**WELWYN HATFIELD BOROUGH COUNCIL
DIRECTORATE OF STRATEGY AND DEVELOPMENT**

DELEGATED APPLICATION

Application No: 6/2016/1410/VAR
Location: 12 Rooks Hill, Welwyn Garden City, AL8 6ET
Proposal: Variation of condition 2 (plans) on planning permission
 6/2015/2448/HOUSE
Officer: Miss J Bould

PROPOSED REAR ELEVATION 1:100

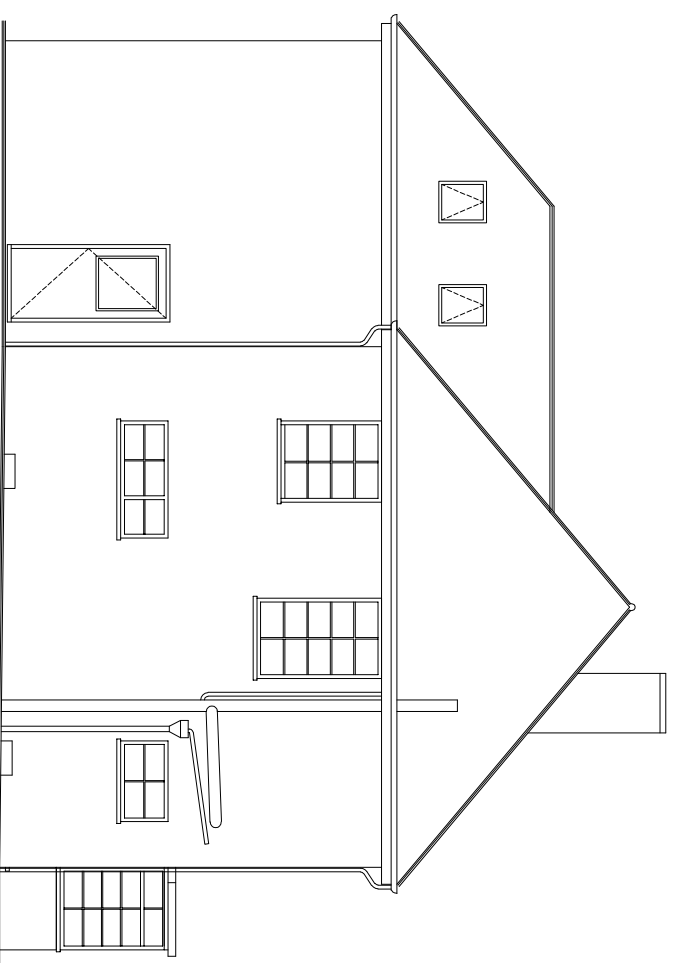
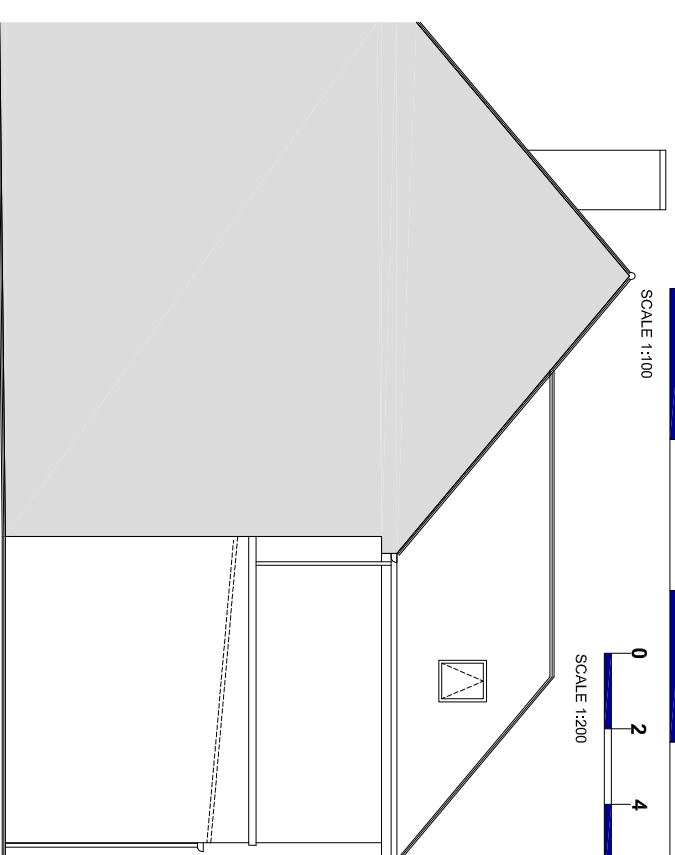
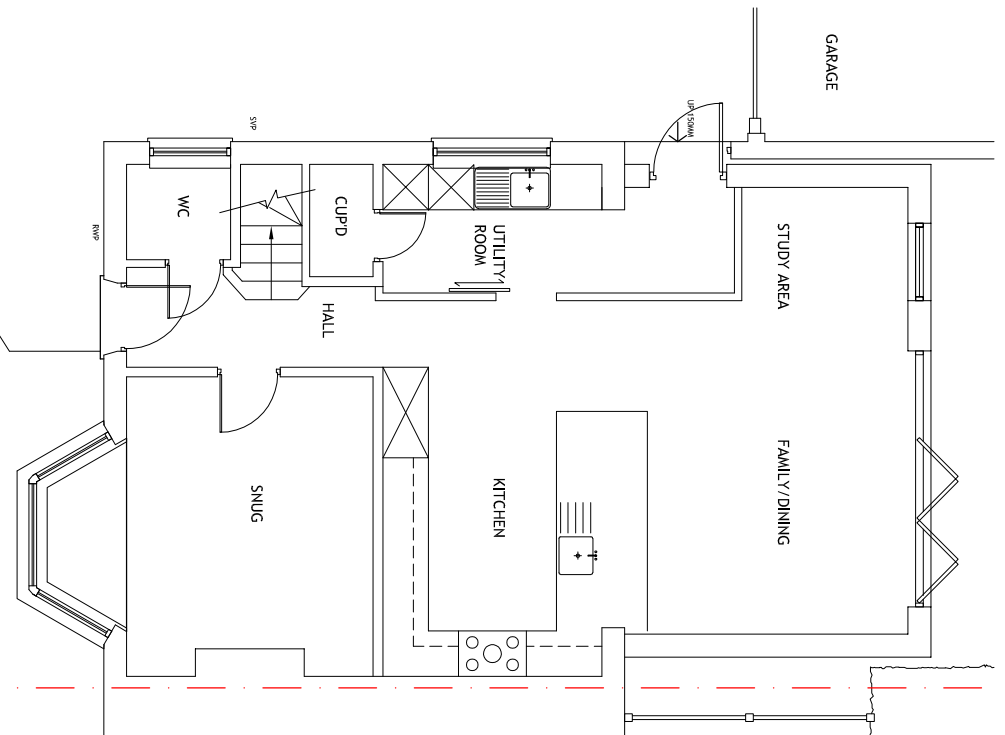
Comment (if applicable):	
The design, scale and bulk of the amended extension is considered to be subordinate in scale to the original dwelling and will not adversely affect the character of the dwelling.	
Would the development maintain the amenity of adjoining occupiers? (e.g. privacy, outlook, light etc.)	
<input checked="" type="checkbox"/> Yes <input type="checkbox"/> No <input type="checkbox"/> N/A

Comment (if applicable):	
The changes to the roof pitch will not change the affect or scale of overlooking between properties. The separation distances between the application dwelling and neighbouring properties are not proposed to change.	
A proposed first floor window to the east elevation is to give light to a bedroom is proposed to be moved slightly and would not change the affect of overlooking. Regardless of window position, a condition requiring obscured glazing and non-opening has been included on the original approval. There is no reason to amend this condition.	
Would the development provide / retain sufficient parking?	
<input type="checkbox"/> Yes <input type="checkbox"/> No <input checked="" type="checkbox"/> N/A

3. The proposed first floor window to the east elevation of the dwellinghouse shall be glazed with obscured glass and shall be fixed so as to be incapable of being opened below a height of 1.8 metres above floor level, and shall be retained in that form thereafter.

PROPOSED SITE/ROOF PLAN 1:200

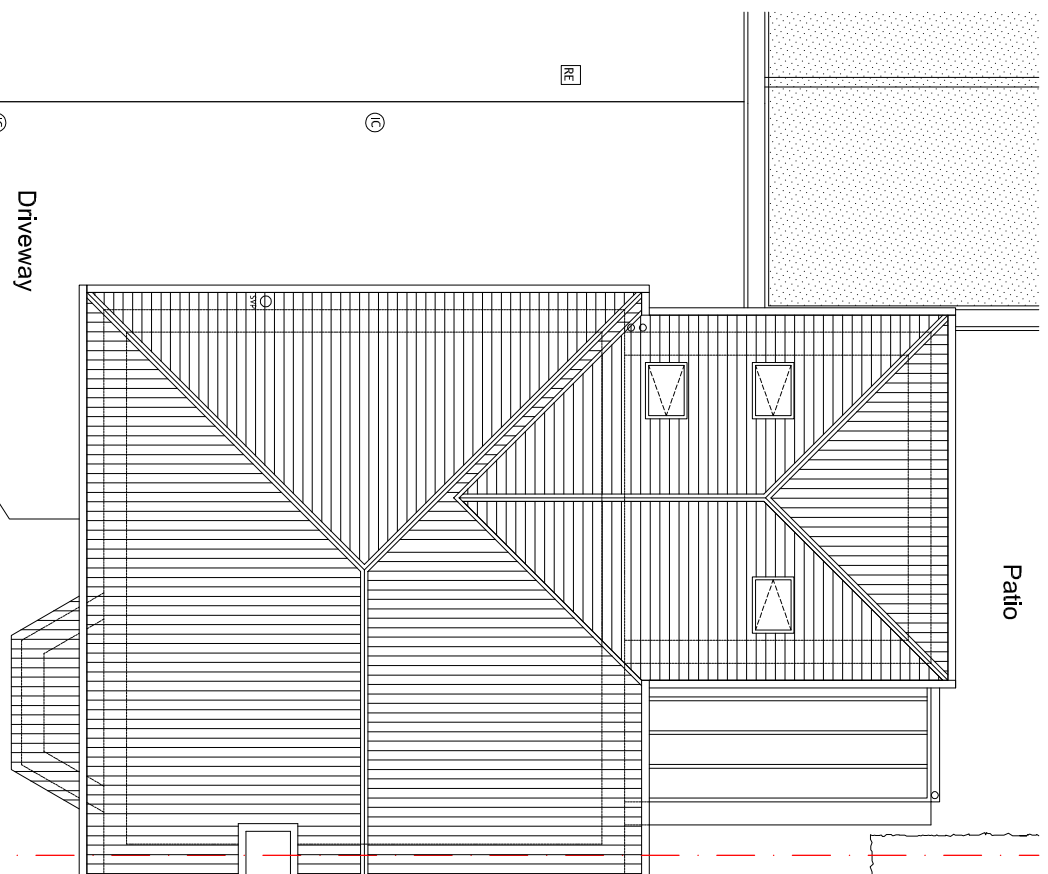
Context			
Site and Application description	<p>The application site is a two storey semi-detached dwellinghouse located on Rooks Hill. The property has a side garage which extends into the rear garden of the property. A conservatory has been added to the rear elevation, sited to the west of the garage.</p> <p>Planning permission to construct a part one and part two storey extension to the rear of the dwelling has previously been granted.</p> <p>This application is for the alteration of the drawings approved under the previously granted permission resulting from a building survey finding the existing roof is of a steeper pitch than originally designed for. In addition, the ground floor extension is proposed to be made more narrow, the repositioning of an existing first floor window, the installation of a third roof light and the repositioning of one of the proposed rooflights on the extension.</p>
